Please ask for: Sian Eggington
Email: sian.eggington@terraquest.co.uk
Telephone: 0121 2341390
Our Ref: LU/146/20/HH
Your Ref:
Date: 22nd June 2020

Application for Planning Permission for Works or Extension to a Dwelling

Development: Extension to provide new shower room, study and dining room.
Location: 7 Shannon Close Littlehampton BN17 6PR

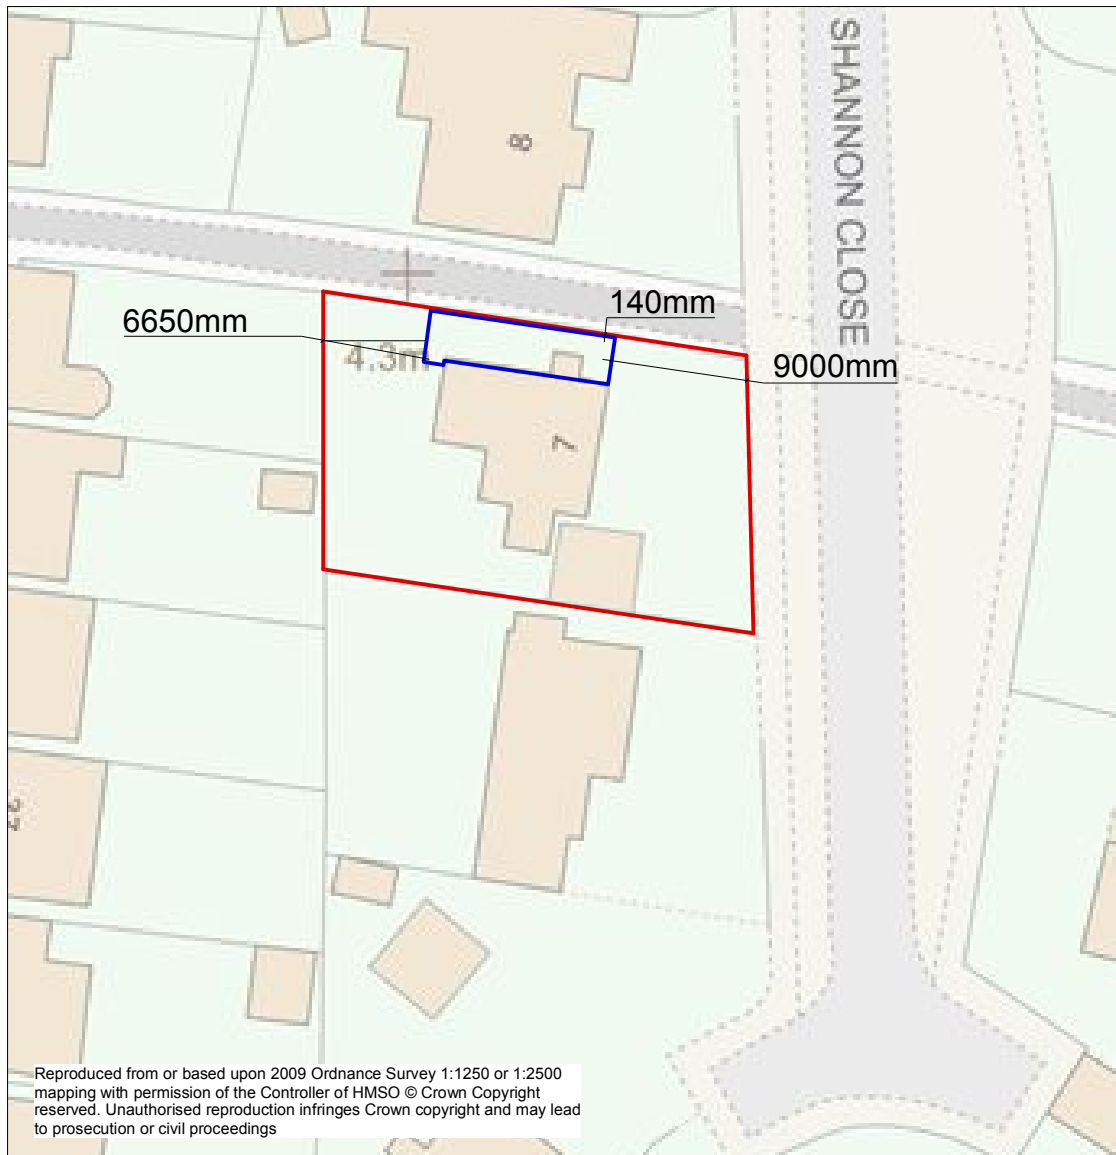
Dimensions: You are required to have dimensions from all extensions to all site boundaries. Please amend.
